ASSESSMENT REPORT

1 Burroway Road, Wentworth Point SSD 6387 MOD 4

Project Title  
**JEWEL RETAIL**  
1 BURROWAY RD. WENTWORTH POINT, THE WHARF SITE.  
SYDNEY OLYMPIC PARK  
Drawing Title  
**ROOF PLAN & SECTION**

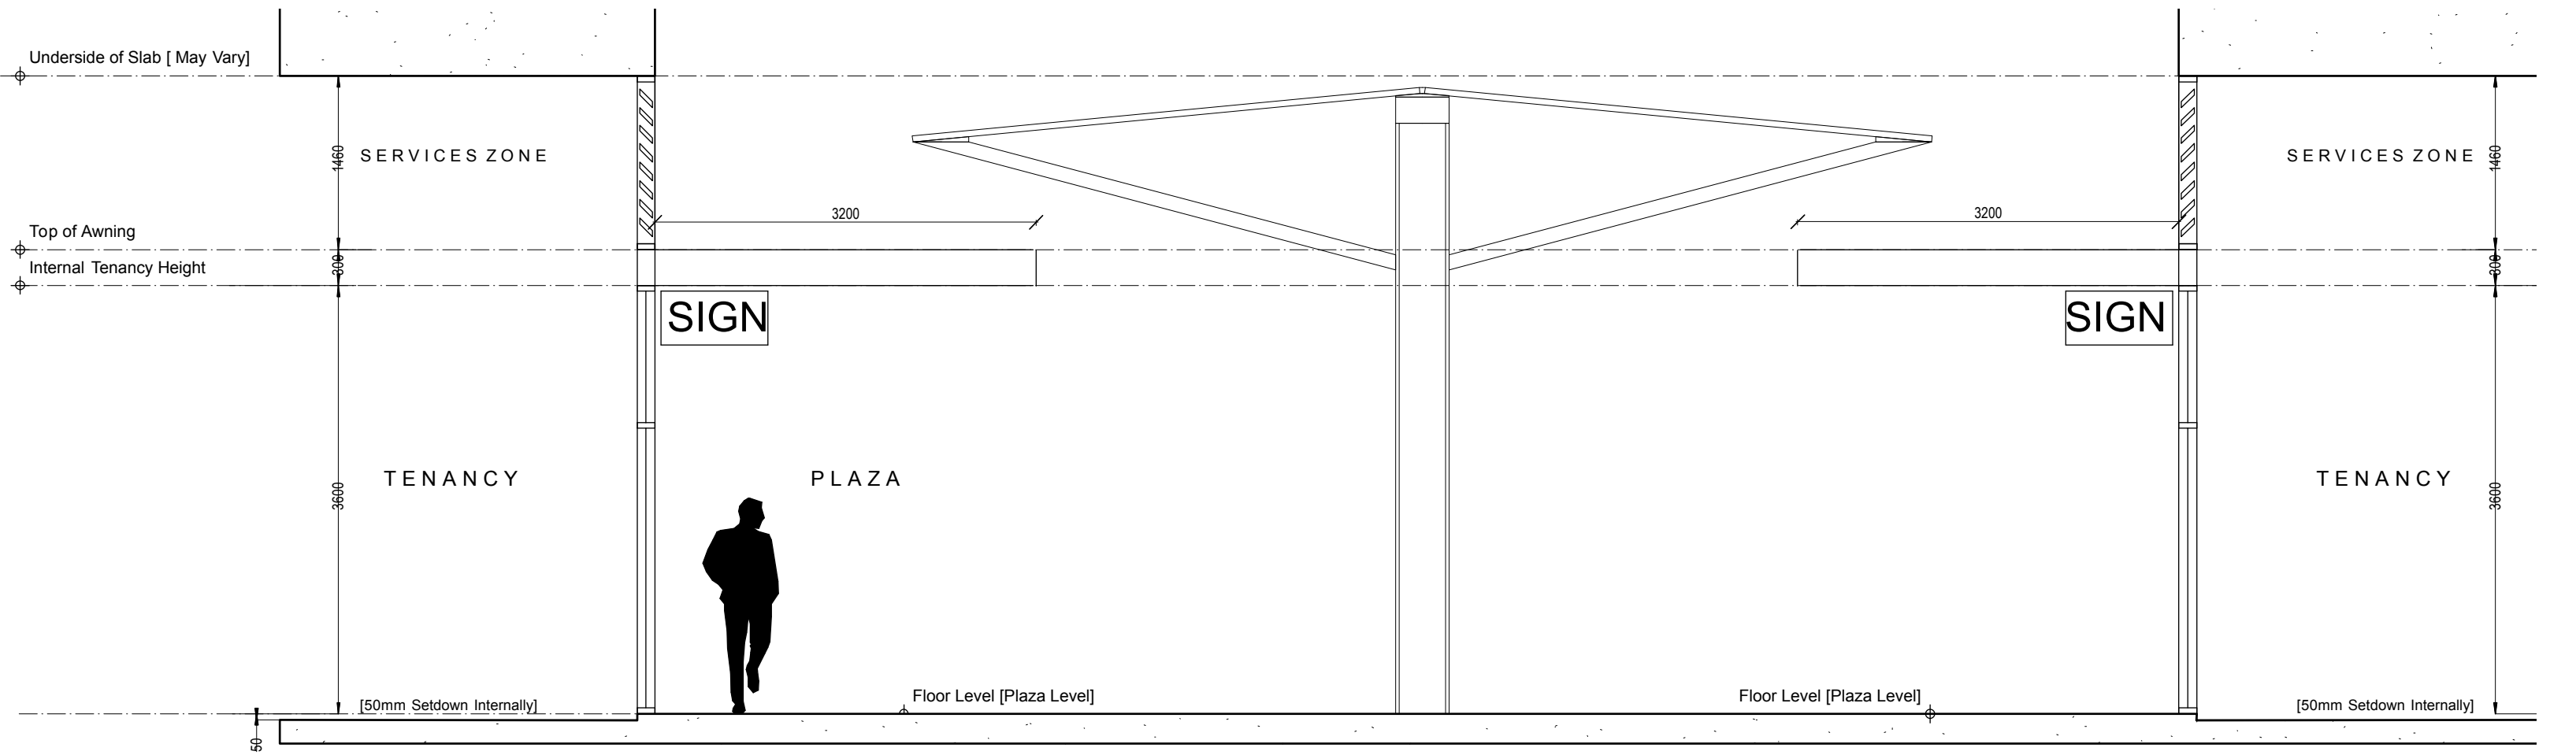
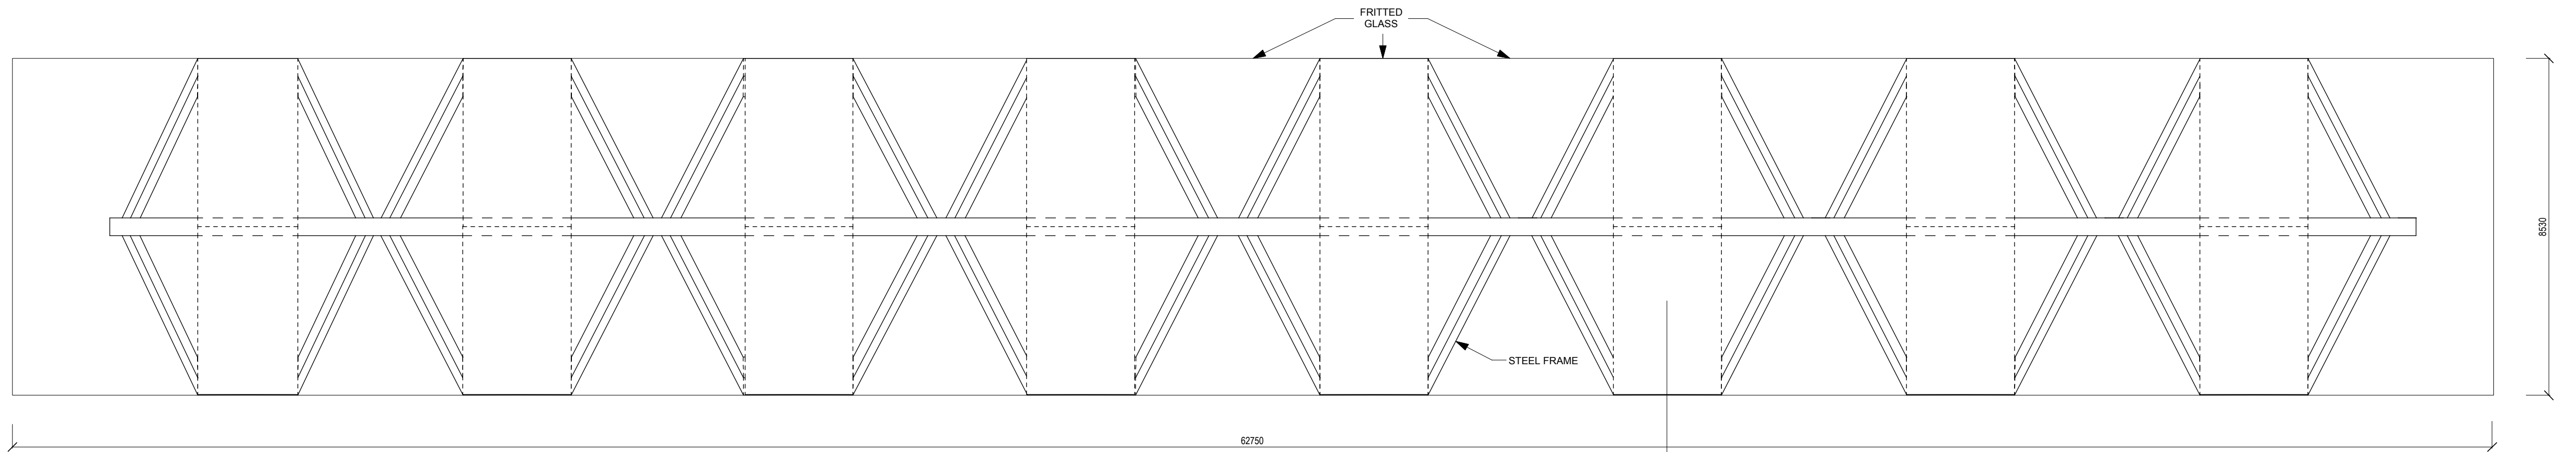
<i>Canopy Design</i>	<ul style="list-style-type: none"> • Council and SOPA are supportive of the proposed canopy. Council recommended the canopy be designed and constructed in accordance with the Building Code of Australia and the plaza maintains appropriate access for people with disabilities. SOPA recommended it be designed to manage stormwater runoff. • The proposed canopy contains intermittent solid sections to provide sunshade and all-weather protection for pedestrians. The design allows for the penetration of light and free movement of air as it spans above the retail awnings below. It would be supported by a single row of columns to minimise impacts on pedestrians and disabled access through the link. • The applicant confirmed rainwater would run off the canopy to adjacent awnings which have sufficient capacity to convey rainwater. • The Department considers the canopy would make a positive contribution to pedestrian amenity. • The Department is satisfied the design would not have an adverse impact on the visual amenity of the site, stormwater management, or disabled access. 	No additional conditions or amendments necessary.
